## Appeal Decision

**Appeal Ref: APP/R5510/D/25/3360139**

**34 Rodmell Close, Hayes UB4 9RS**

- The appeal is made under section 78 of the Town and Country Planning Act 1990 (as amended) against a refusal to grant planning permission.
- The appeal is made by Mr Anujan Theivendram against the decision of the Council of the London Borough of Hillingdon.
- The application Ref is 73415/APP/2024/2519.
- The development proposed is single storey front and side extension to existing dwelling house with habitable rooms in roof and dormer to front and rear.

TITLE: DESIGN PROPOSAL - EXTENSIONS
 FLOOR PLANS & ELEVATIONS

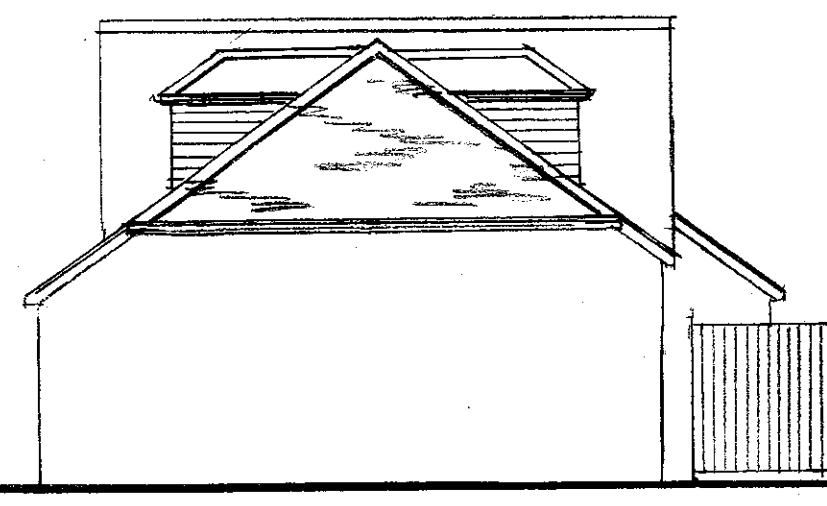
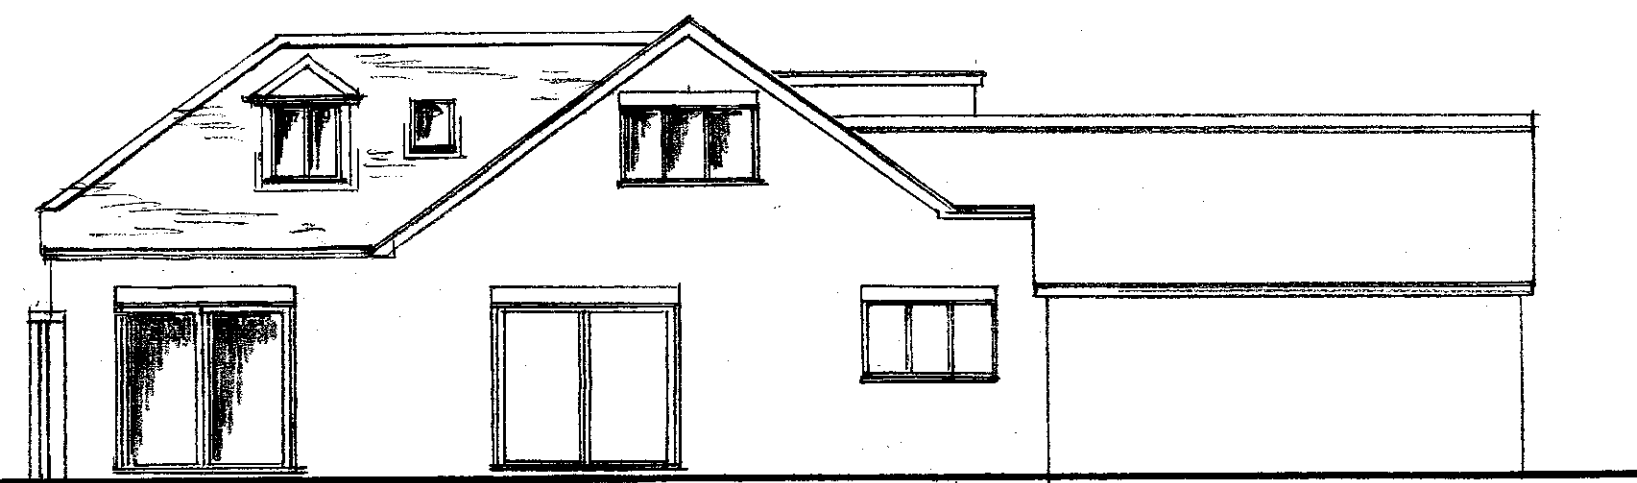
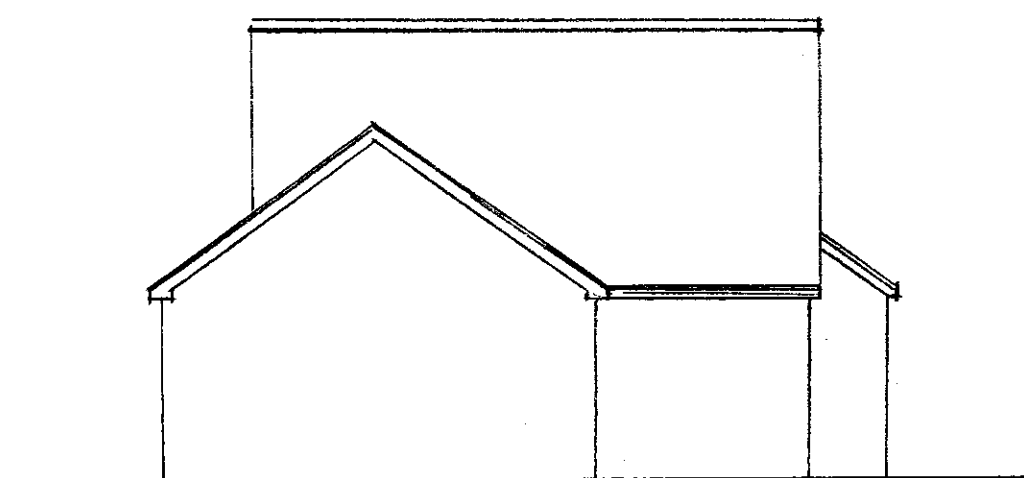
7. The proposed front extension would not protrude beyond the existing front porch or the building line of the neighbouring property on Rodmell Close. However, the side extension would extend very close to the Ditchfield Road boundary and significantly forward of the front elevations of dwellings to this side of Ditchfield Road. Consequently, it would conflict with Policy DMHB 11 (Design of New Development) of the Hillingdon Local Plan Part 2 - Development Management Policies (2020) (HLPP2) which requires extensions to harmonise with the local context in relation to, amongst other things, building lines and set backs.

8. Moreover, as a result of its scale and position, the extension would largely consume the space between the side elevation of the host dwelling and the pavement, which currently makes an important contribution to the spacious characteristics of the street. Again, this would be contrary to the HLPP2, with Policy DMHD 1 (Alterations and Extensions to Residential Dwellings) requiring proposals for extensions to corner plots to maintain the openness of the area. Therefore, due to the prominent corner location and the scale and bulk of the side extension, the appeal proposal would appear as an incongruous and overly dominant addition to the property and would unacceptably erode the rhythm of built form and the sense of openness on Ditchfield Road.

9. I have been supplied with evidence from the appellant of local examples that they feel are similar to the proposed development. Whilst I acknowledge that building lines in the surrounding area are not uniform, the relative alignment of the appeal proposal to the nearest neighbouring properties on Ditchfield Road, and its position very close to the roadside boundary in this instance, would not positively respond to the appeal site's immediate surroundings. Even if there is variation in roof form in the area, this does not overcome the harmful effect resulting from the scale and siting of the proposal close to the roadside boundary on Ditchfield Road. Furthermore, the existing boundary fence on the appeal site is not comparable to the height of the extension, nor would it effectively assimilate the bulk of the proposal into the street scene.

ATTIC LEVEL PLAN

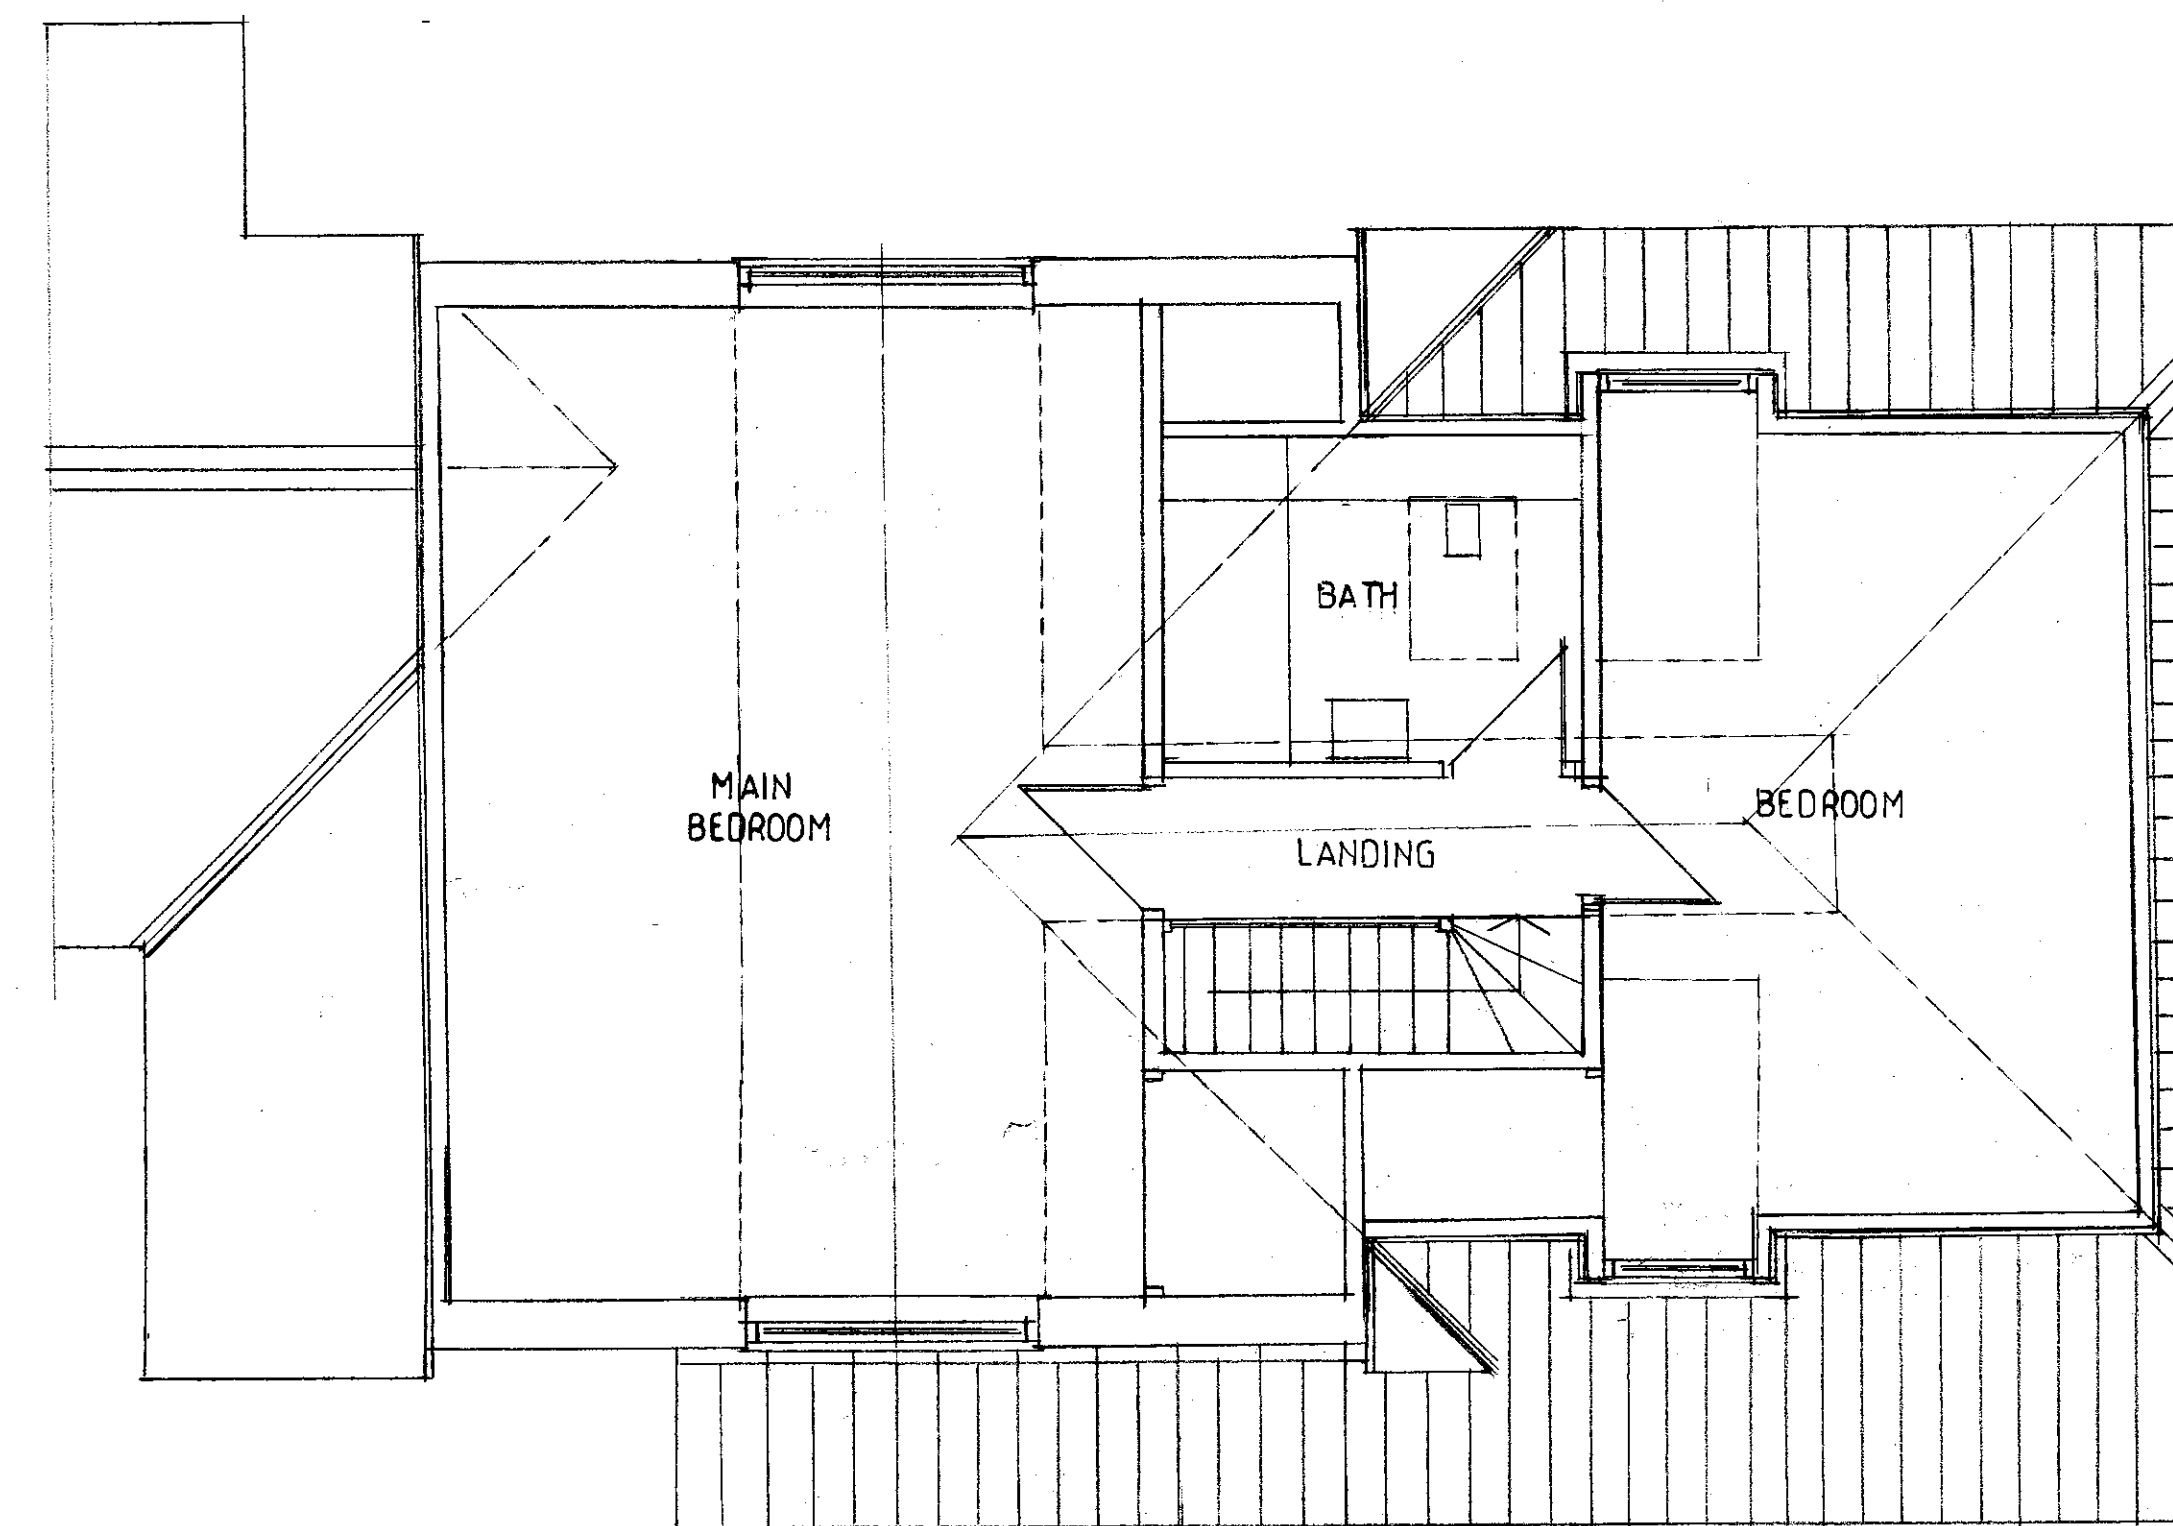
11. The back garden of the appeal site is modest in depth, and the proposed rear dormer would afford close up, direct views into the private garden of No 30, leading to a loss of privacy for these occupiers. However, the appellant has indicated they would be agreeable to a condition to mitigate the potential of overlooking, by means of obscure glazing. Whilst it may not always be appropriate for the window of a habitable room to be obscure glazed, the bedroom which this window serves would be dual-aspect and the additional front dormer would ensure acceptable outlook would be provided from this room for occupiers of the host property. I therefore agree with the appellant that provided that the rear dormer window were to be obscure glazed, and that any such condition also required the window to be fixed shut to a specified height above internal floor level, this would ensure the privacy of the occupiers of No 30 would be maintained.
